**Beaches Yard,  
Horton Road,  
West Drayton**

**Prepared for  
Harvest Land Management**

**SMA Ref: 6969/TAA**

DOCUMENT CONTROL			
Project	Beaches Yard, Horton Road, West Drayton		
Job No.	6969		
Document Title	Transport Assessment Addendum		
File Location	\Smadata\data2\Admin Project\6900 to 6999\6969 - Warehouse near Heathrow\Reports		
Prepared by	Rhys Donoghue	Date	20/02/2023
Reviewed by	Rhys Donoghue	Date	21/02/2023
Approved by	Dave Wiseman	Date	21/02/2023
Document Issue	Description / Changes	Revised by	Date
01	Issued for Client Review	RD	21/02/2023
02	Revised as per Client Comments	RD	24/02/2023
03	Minor Revisions to Report	RD	24/02/2023

REVISIONS				
Preliminary	Approval	Tender	Const.	
DRAWING STATUS				
DATE	AUGUST 2022	DRAWN	TAQ	CHECKED
			RD	ISSUE
DRAWING No.	6969.003	REV	D	SCALE
				1:250 @ A3

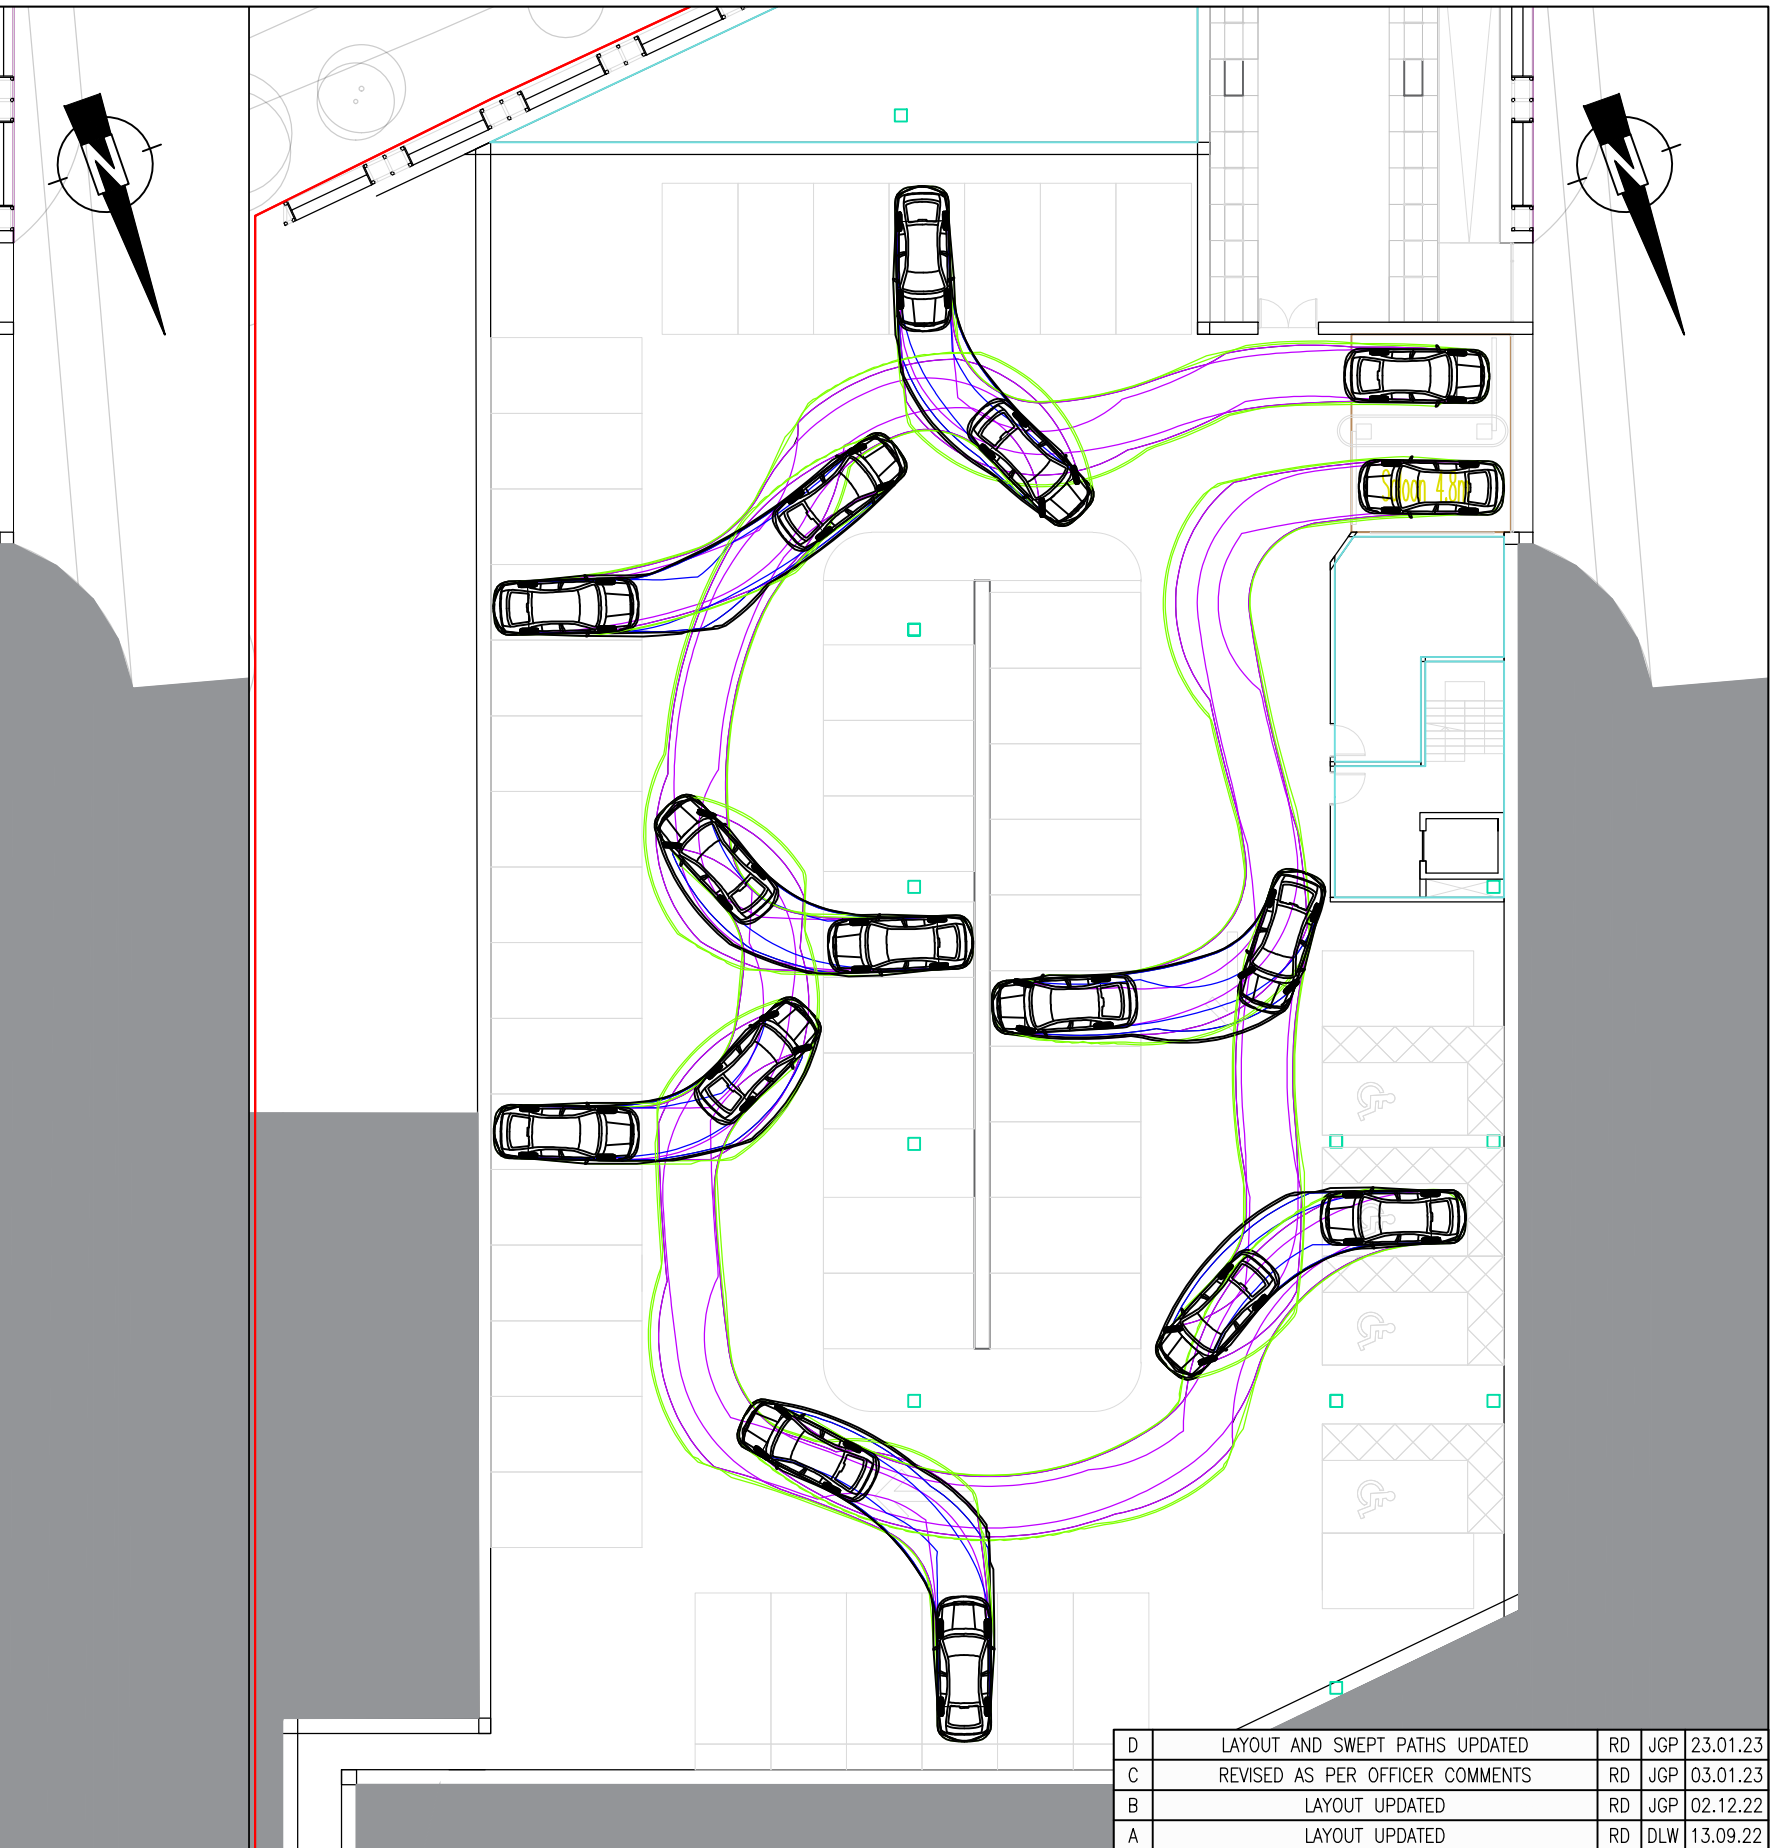
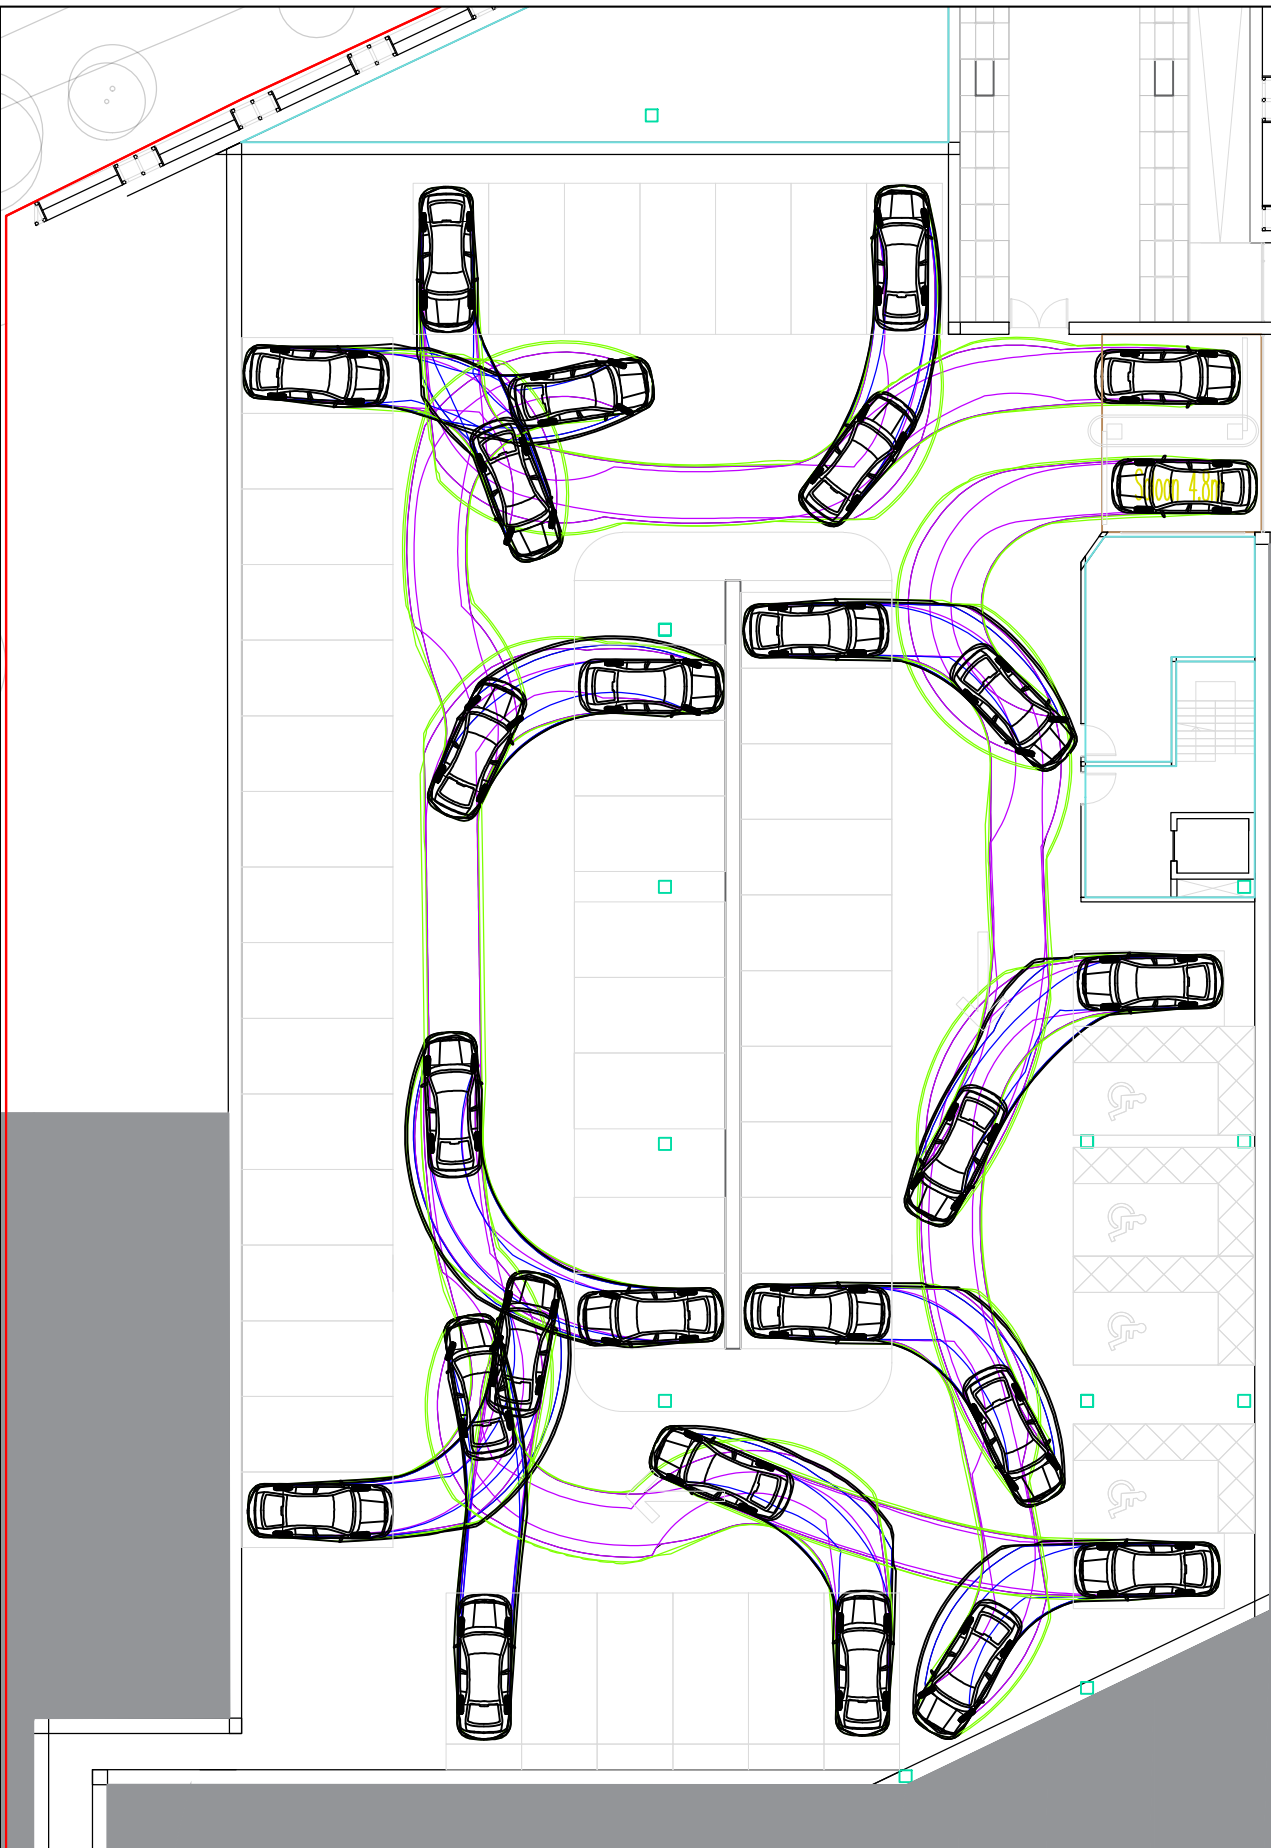
Amended plans now indicate that the private road outside of the development are within the applicant control through the new red boundary line that is seen on plans. It is good to see that some enforcement will be made by preventing cars from parking on the road through the installation of double yellows. Nevertheless, the Highway Authority would require that more improvements be made to the road that would improve road safety and make it more suitable for HGV use. It is noted that the footpath will be widened on the side of the development, though this does not lead anywhere for pedestrians to go. Furthermore, nothing has been proposed to restrict vehicles from exiting both the basement car park and loading bay that ensures that drivers check to approaching vehicles. Finally, the Highway Authority would require that the applicant demonstrate how further improvements can be made to the road which increase road safety. This contradicts the published London Plan 2021 Policy T4 Assessing and mitigating transport impacts which states that '*development proposals should not increase road danger*'.

2.15 To ensure the safety of pedestrians on Horton Road and those crossing the junction with the access road, it is proposed that access road is widened and the road markings are realigned to better suit the widened access. The proposed widening and line markings are shown on **Drawing 6969.001F**. Autotrack Swept Paths for a range of vehicles at this junction are shown on **Drawing 6969.002F** and **6969.003F**.
